Department of Planning. Proposed 193 Lot Residential Subdivision.
Lot 112 DP 1073791. Lyons Road. Bonville.

I refer to your letter received on 3 February 2011 by the Roads and Traffic Authority (RTA) for the proposed subdivision.

Roads and Traffic Authority

4.2 Total Traffic Generated

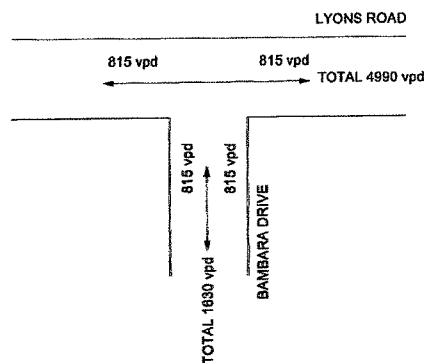
- iii. Very little detail has been provided of the proposed arrangement for the junction of Lyons Road and Bambara Drive.
- iv. The traffic generation for the existing and proposed subdivision appears to have been underestimated. The industry standard is generally 10 trips/lot. This could have a significant impact on the performance of intersections and the life of Lyons Road. It could generate another 1930vpd rather than the estimated 881vpd and all of the subdivision could have a total generation of 3440vpd.
